## City of Albuquerque

May 23, 1986

RE: REVISED DRAINAGE PLAN OF COMMERCIAL BUILDING, 308 MOUNTAIN  
ROAD, NE, RECEIVED MAY 22, 1986 FOR CERTIFICATE OF  
OCCUPANCY APPROVAL (J-14/D32)

GRADING & DRAINAGE PLAN

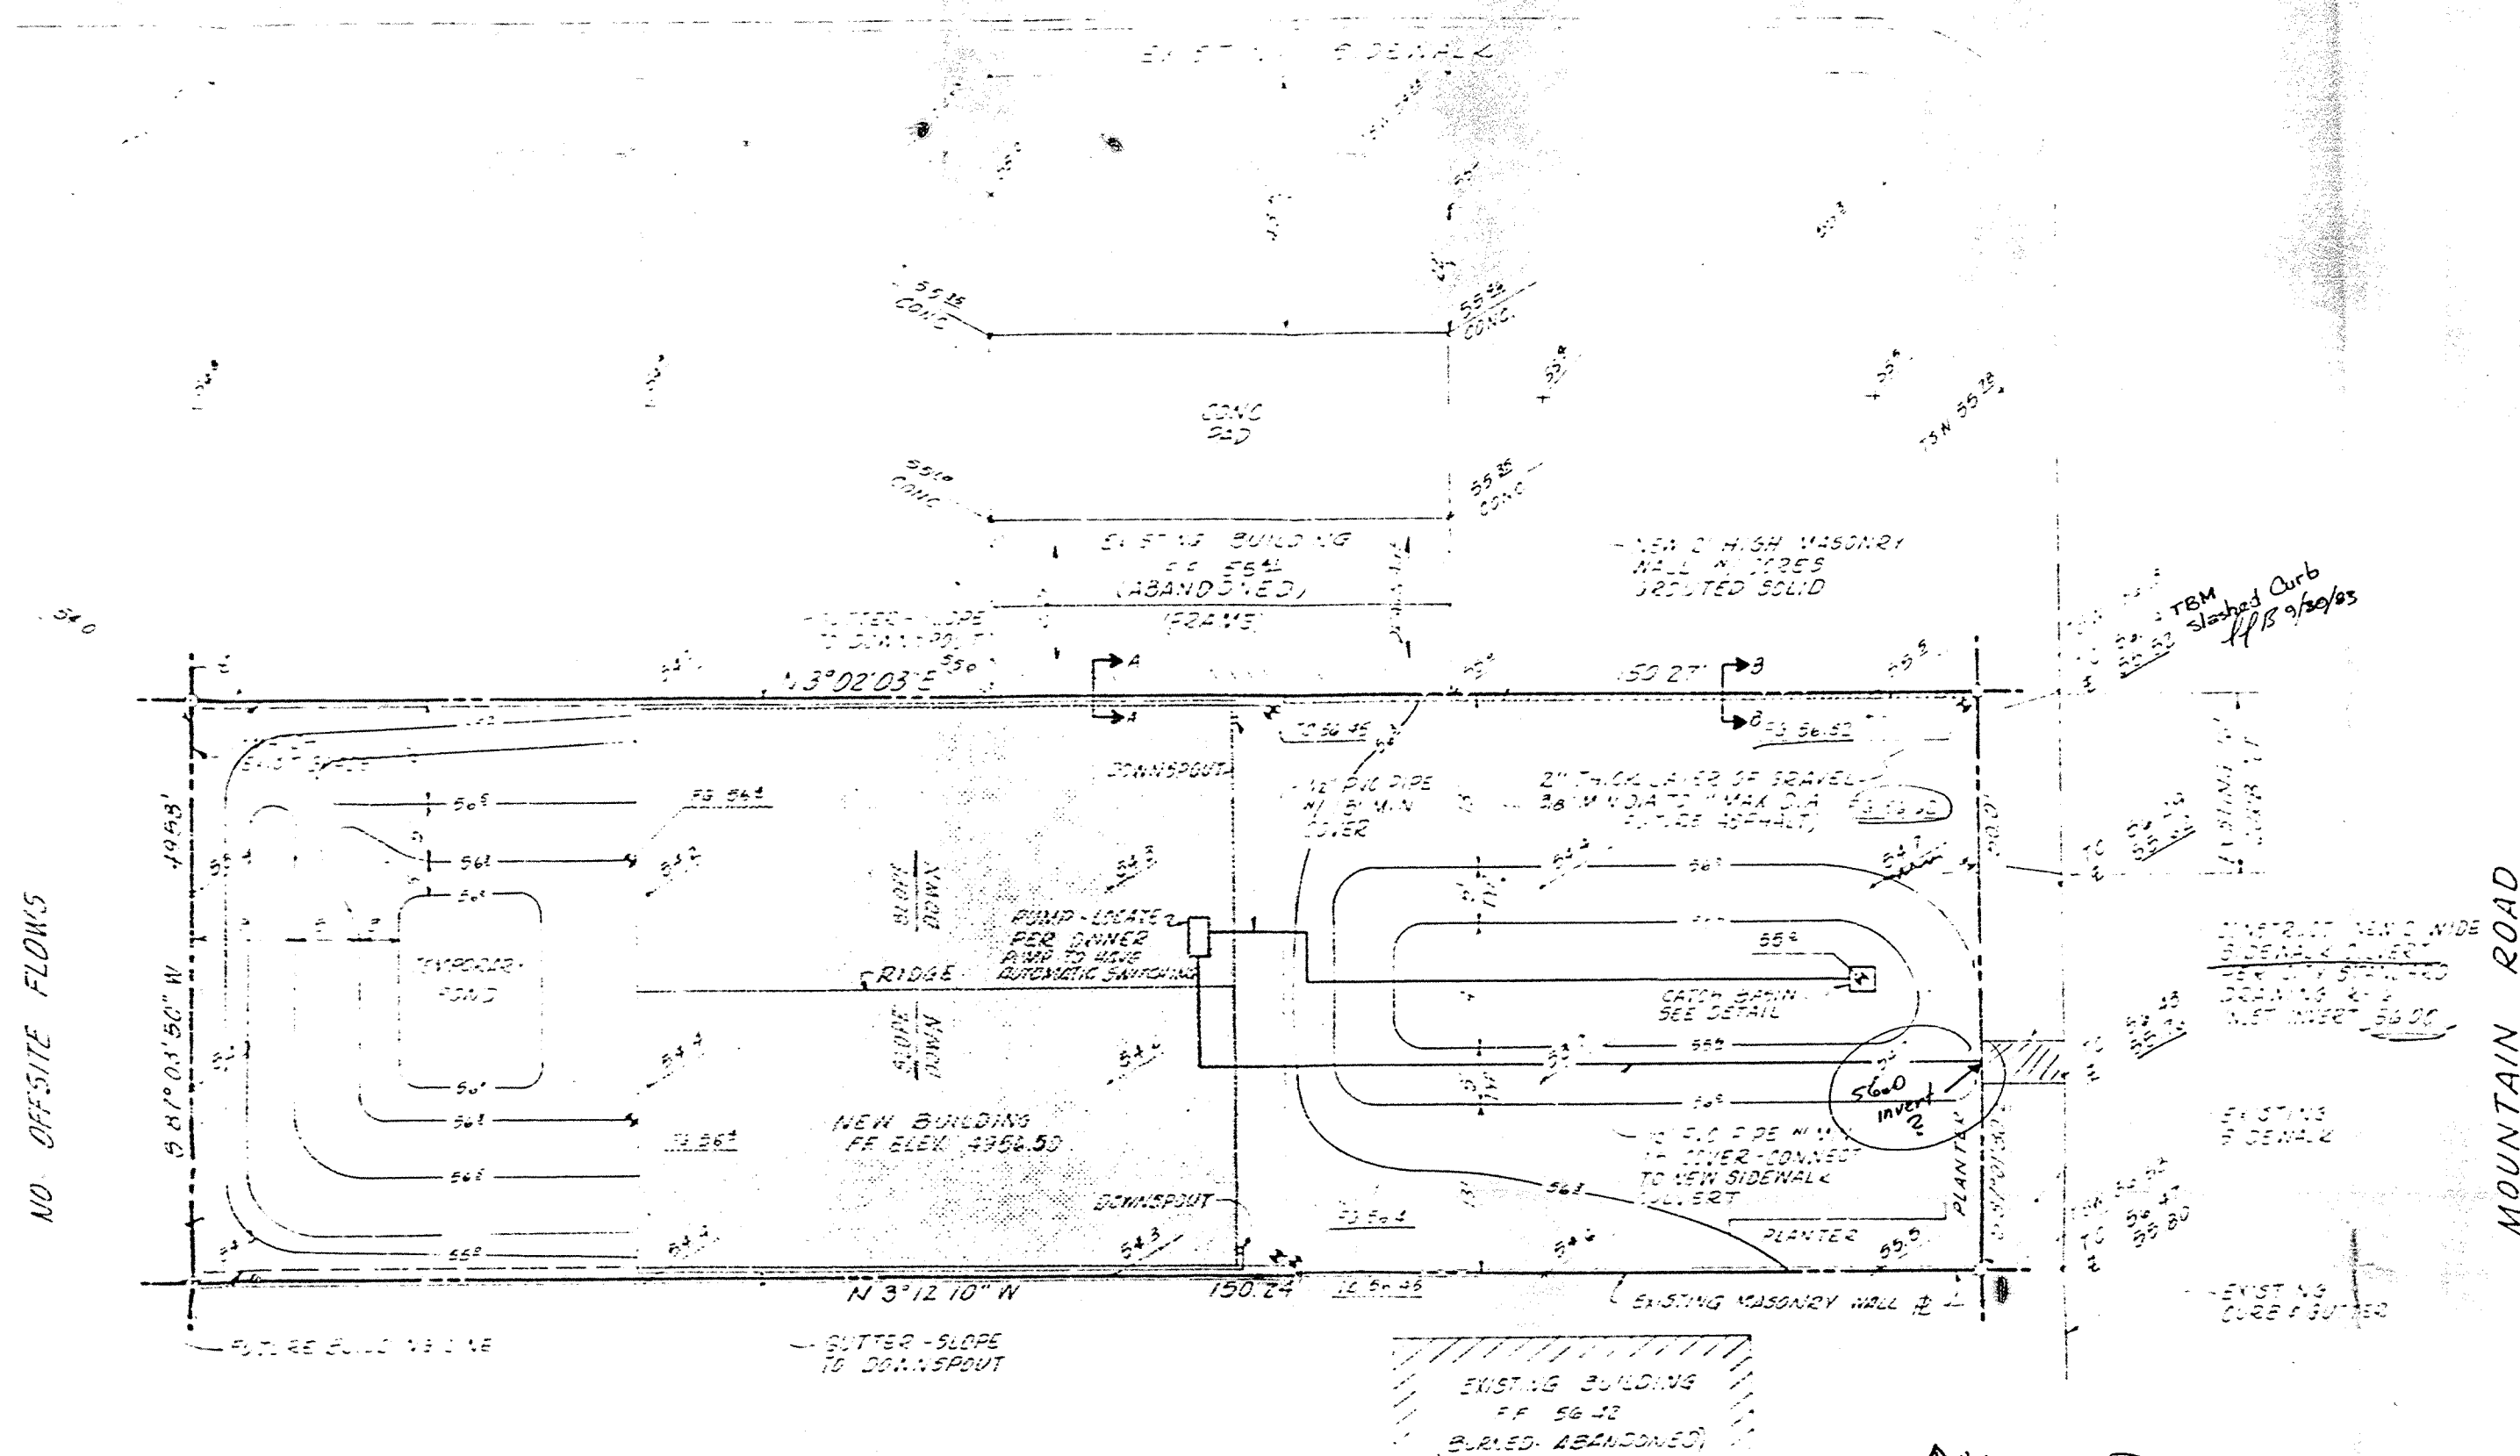
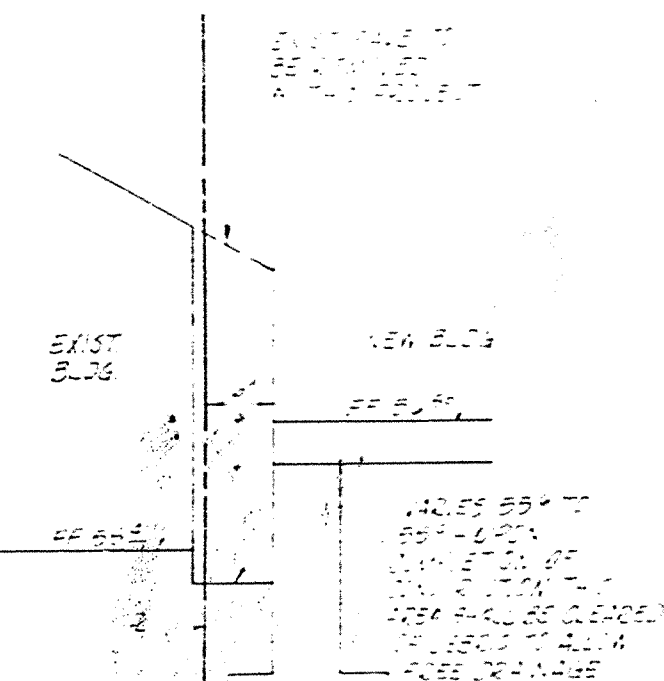
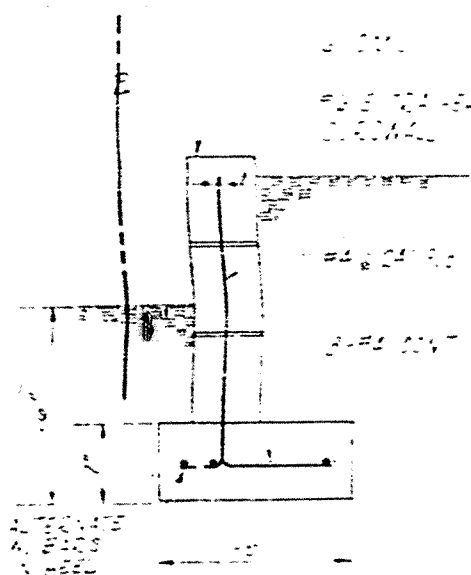
The above referenced submittal, dated May 21, 1986, revising the Grading Plan, dated February 4, 1985, is approved. This approval eliminates the requirement for a fixed permanent sump pump provided all the proposed parking area and sump elevations are constructed as designed. The proposed sidewalk culvert will act as the emergency spillway for the ponding area and outlet for portable sump pump. The landowner will have to provide a portable sump pump to remove ponded storm runoff.

As per our telephone conversation (this date) I am requesting that the approved drainage plan be revised by this letter to eliminate the fixed position sump pump. It is further requested that the owner be allowed to use a portable pump in lieu of the original design.

This request will affect the land of the property owner only as the pump is in a pond in his parking lot. Overflow from the pond (assuming the pump is not used) is directed to Mountain Road through an in-place sidewalk culvert and the drive pad.
